Building Two Advanced Manufacturing Research Facility (SSD-58591961- Mod-1)

Subject: Response to Request for Additional Information No.2

Figure 1: Stage 1 – Site Plan

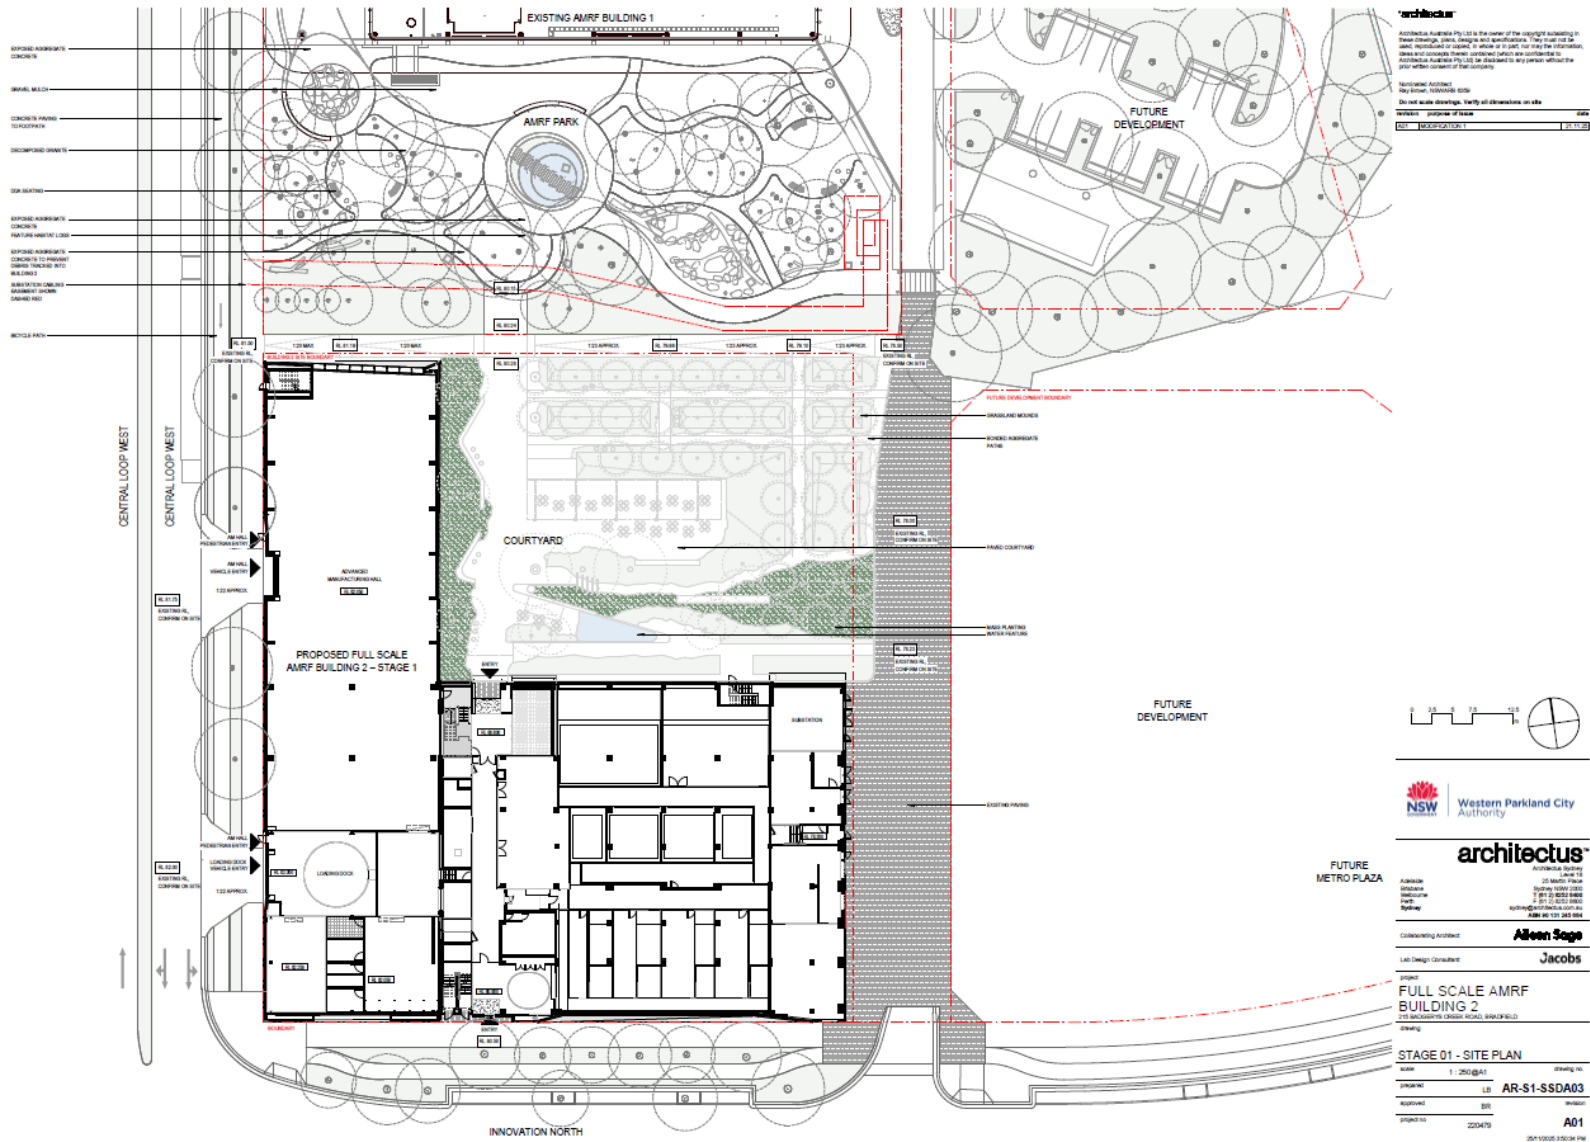
LCC has sought additional information in relation to public domain interfaces and justification of the proposed changes to the courtyard water feature.

Updated public domain plans were provided within the updated Architectural Plans at plan sheet: STAGE 01 - SITE PLAN (AR-S1-SSDA03) and STAGE 02 - SITE PLAN (AR-S2-SSDA03).
